ENG-SF23007-R1-CDs-GEC.pdf Markup Summary

Subject: Line
Page Index: 1
Date: 4/18/2023 2:52:23 PM
Author: Mikayla Hartford
Color: ■
Layer:
Space:
Page Label: [1] COVER 1

WATERBURY FILING NO. 1
 CONSTRUCTION SET
 ROUNDABOUT DETAILED GRADING

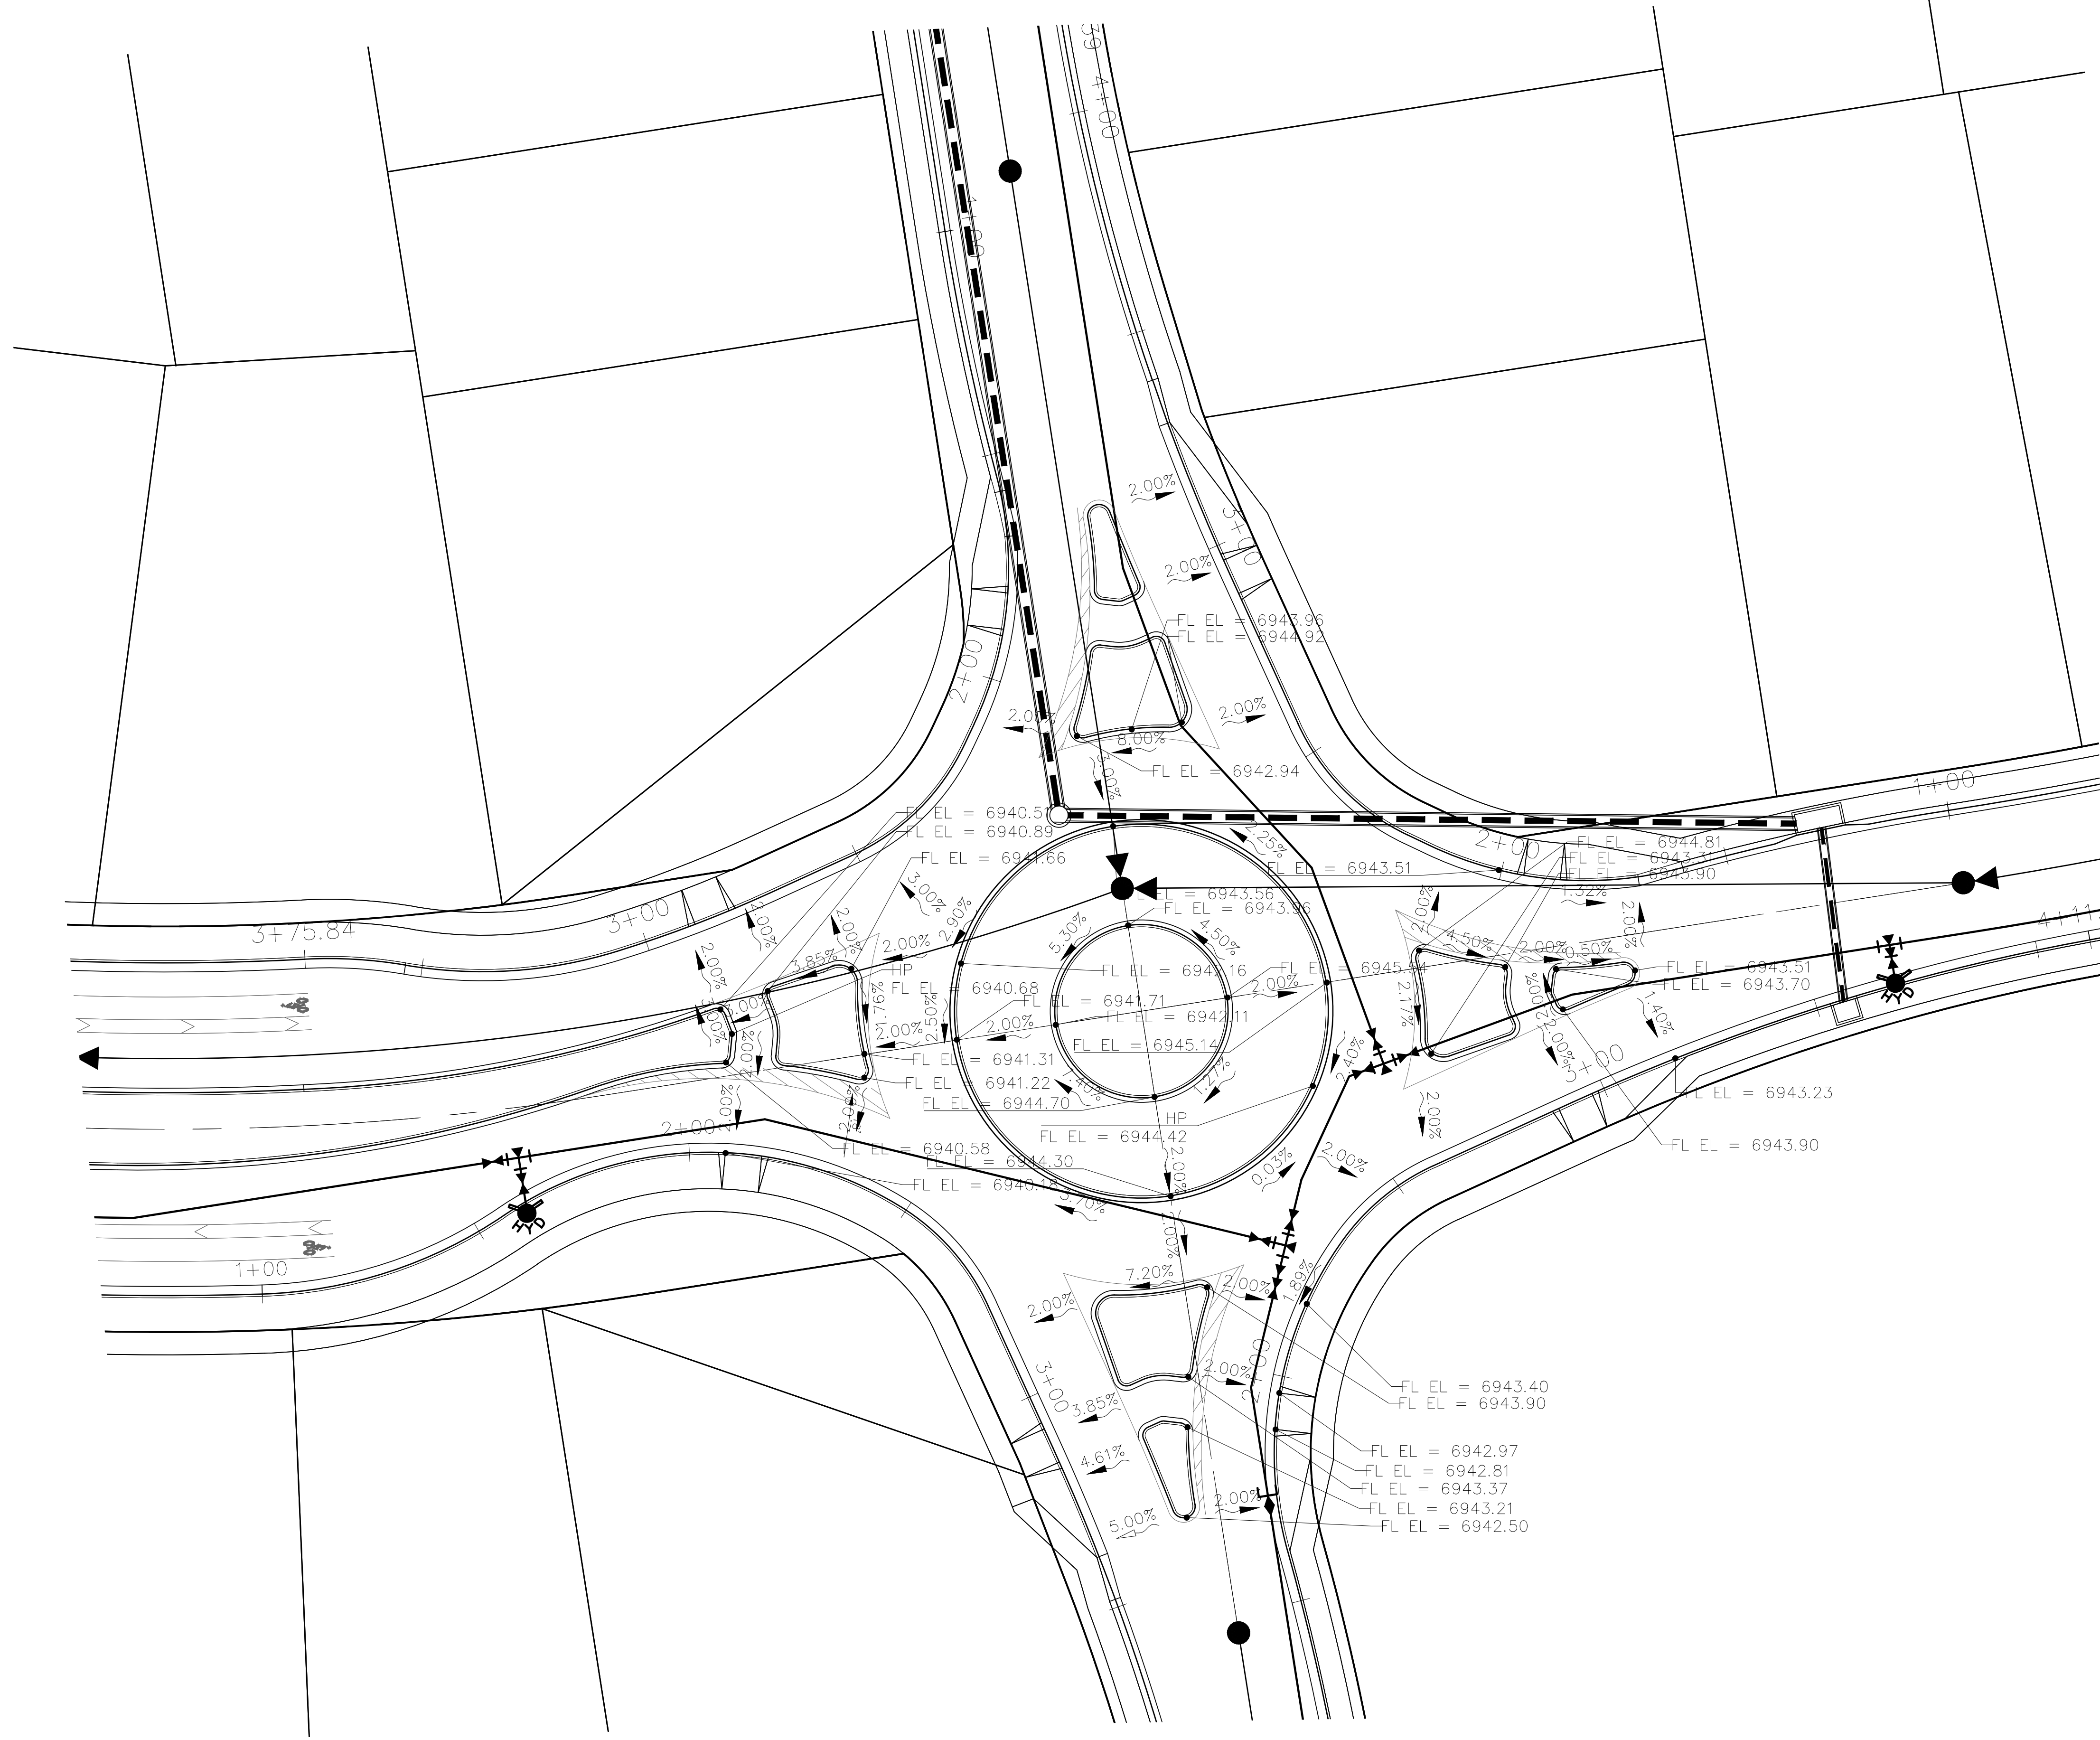
Call out design material per TIS page 155. Show limits and material of mountable truck apron

WATERBURY FLING NO. 1
 CONSTRUCTION SET
 ROUNDABOUT DETAILED GRADING

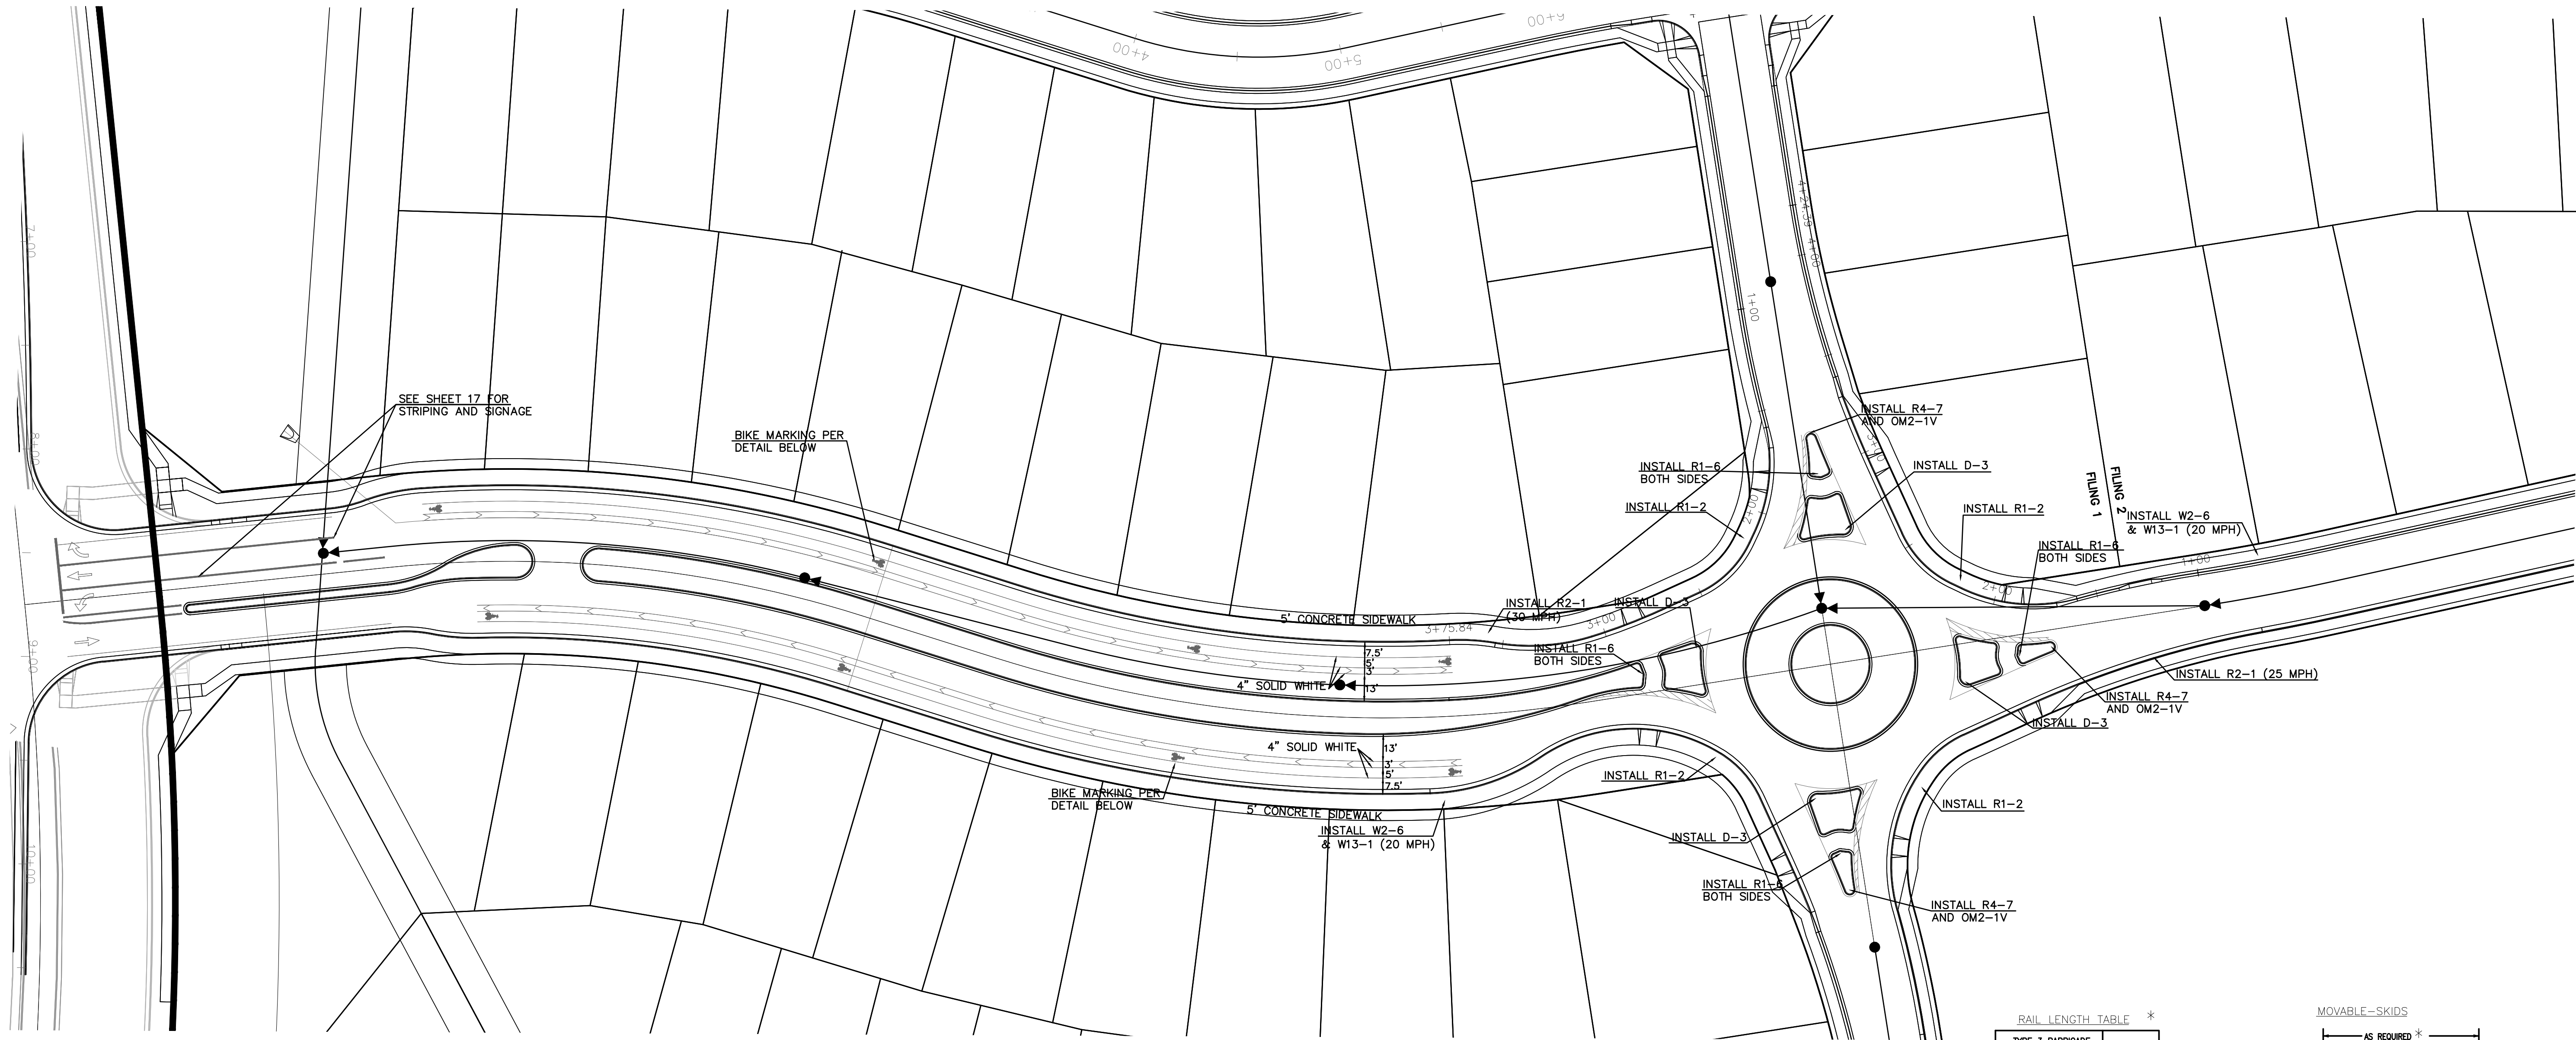
Add scale and north arrow

Add plowable nose on all approach medians
Add plowable nose standard detail SD2-22

Label cross-slope
